October 15, 2013
13251

Level III Site Plan Application
Seaport Lofts: Submittal No. 6

SUMMARY OF RESPONSES TO NEIL DONALDSON EMAILED COMMENTS DATED OCTOBER 09.

**SHEET 5 OF 14**

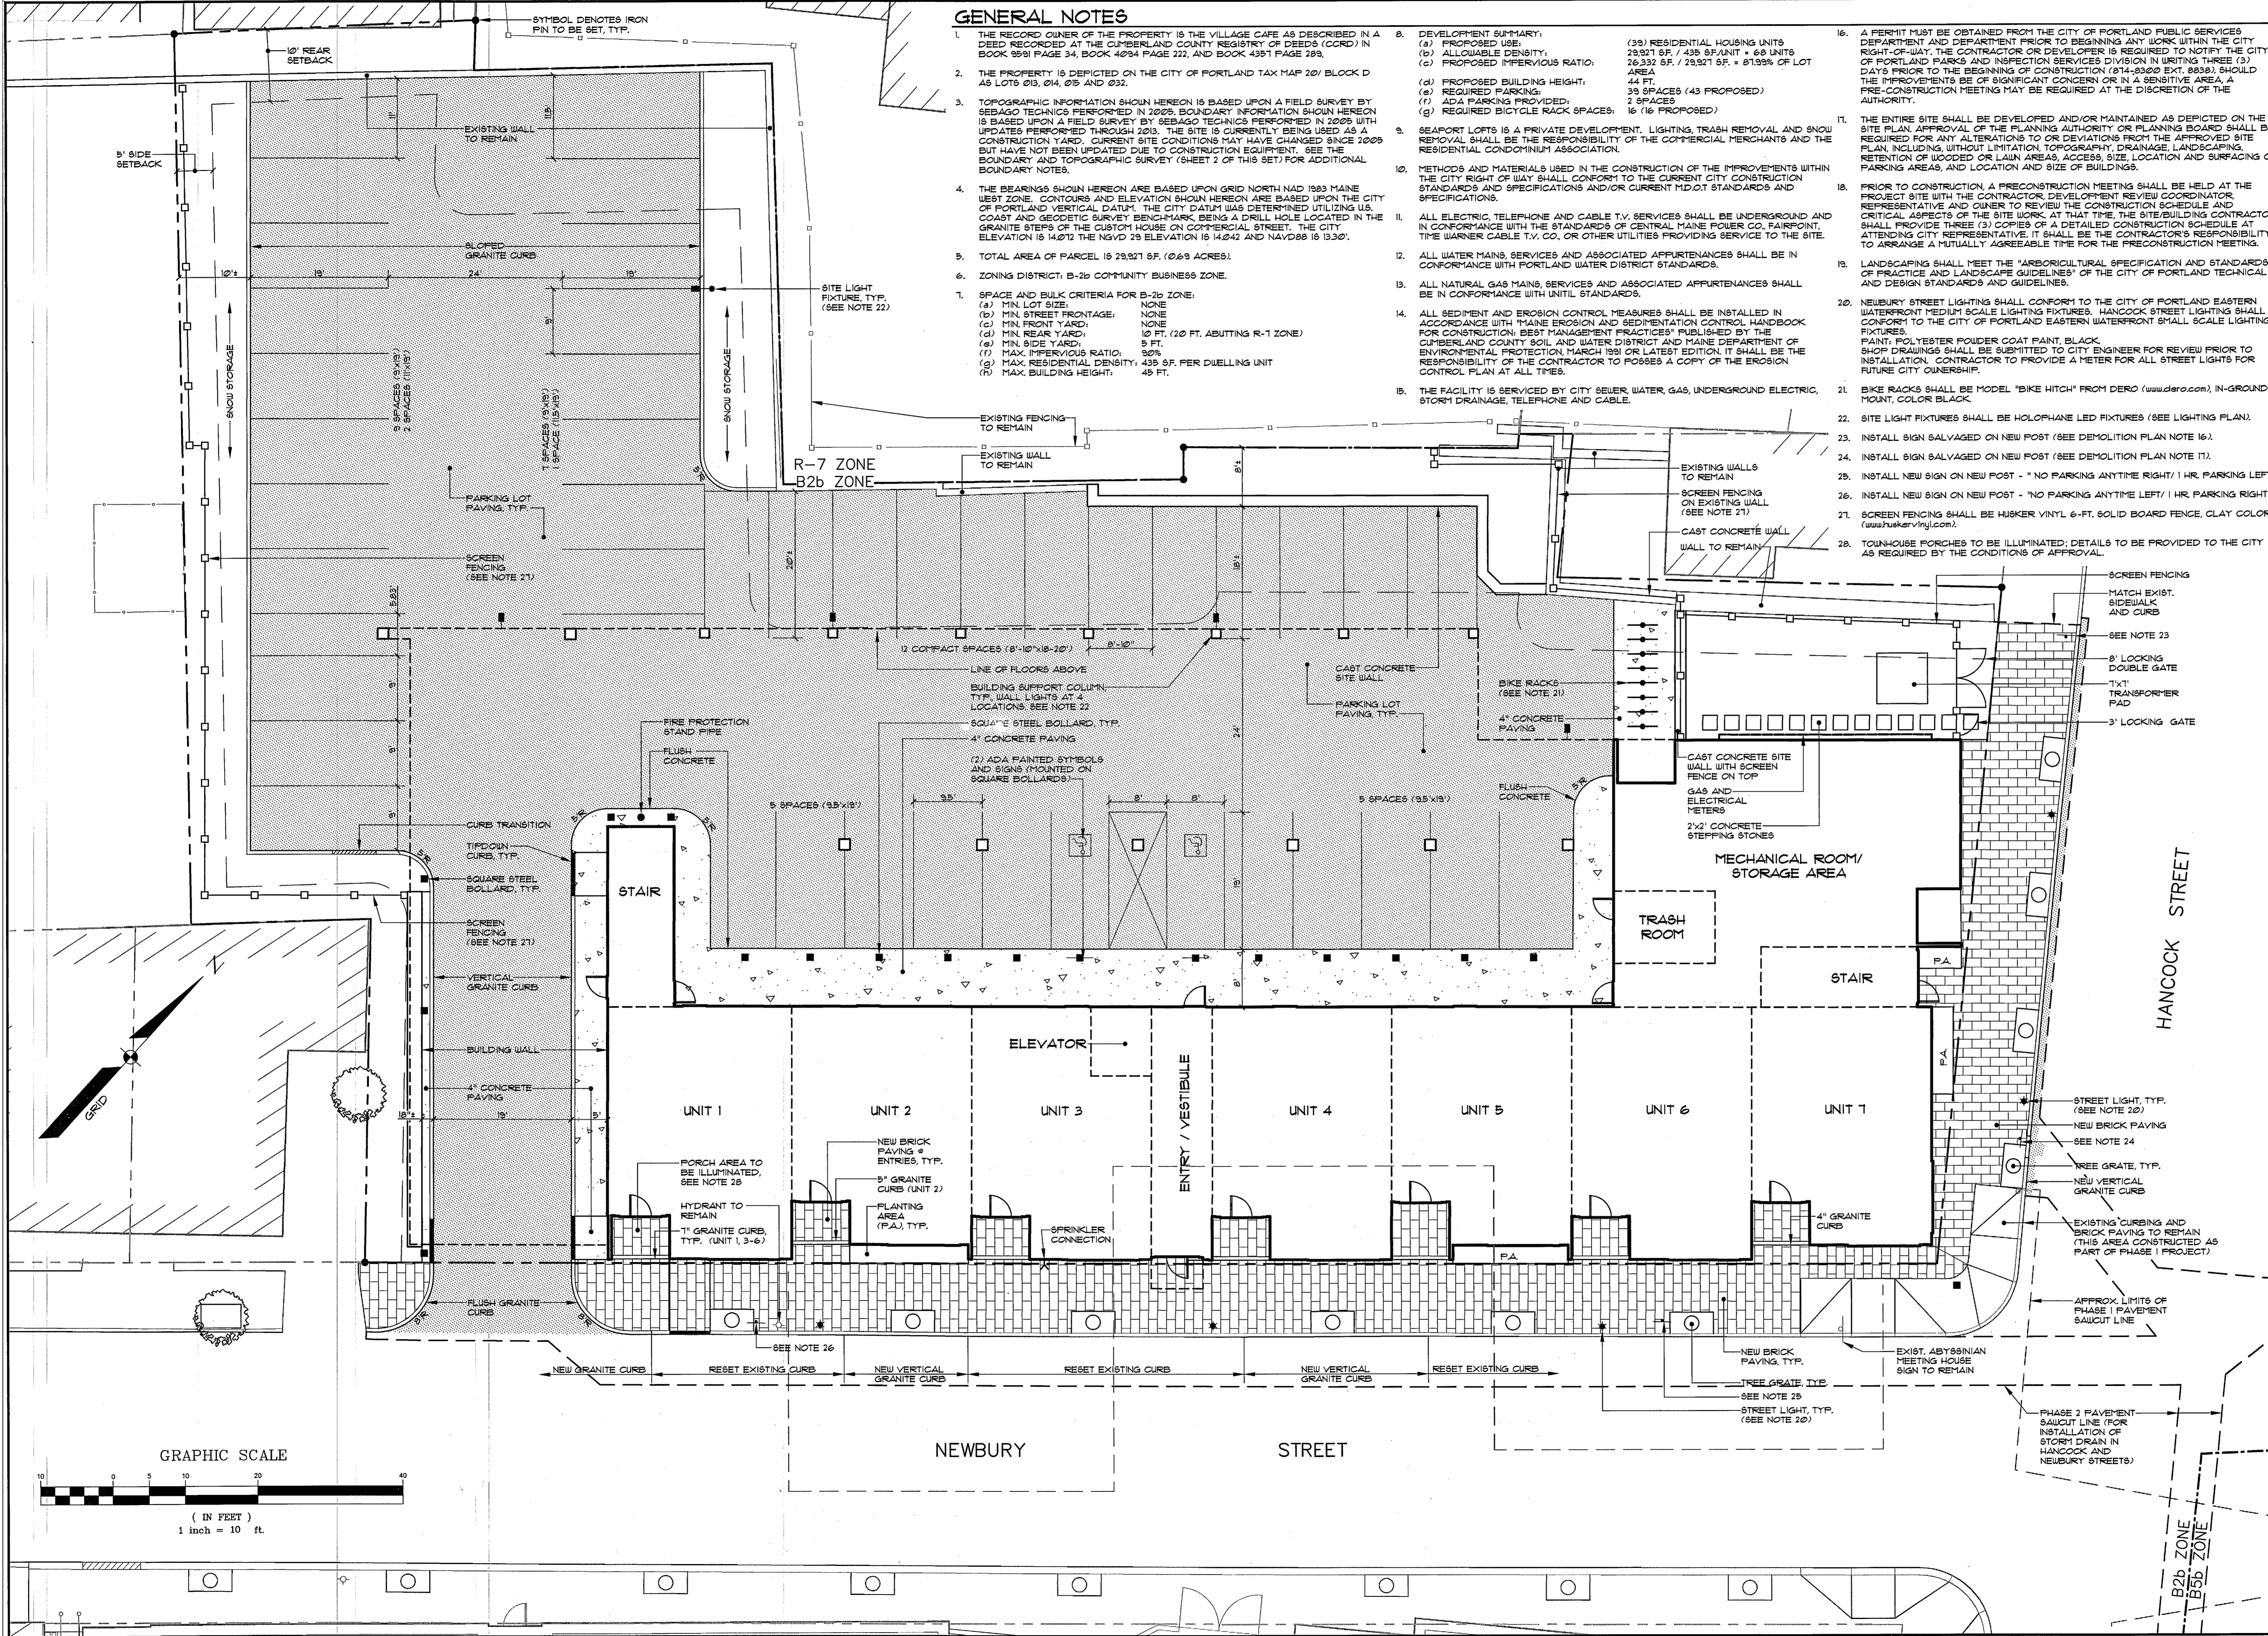
1. We understand that David Senus and Marge Schmuckl are satisfied with prior responses and have no further comments.
- 2a). The site drawings have been updated to reflect changes to the building footprint and canopies.
- 2b). We added a note on the Site Plan that the townhouse entries will be illuminated "with details to be provided to the City per conditions of approval".
- 2c). We have selected a more contemporary, less ornate wall mounting bracket for light fixtures – see Revised Attachment T- Lighting Cut Sheets.
- 2d). Note # 23 on the Subdivision Plat has been revised as requested.
- 2e). The stormtech/ subsurface detention system has been added to the Subdivision Plat as requested.
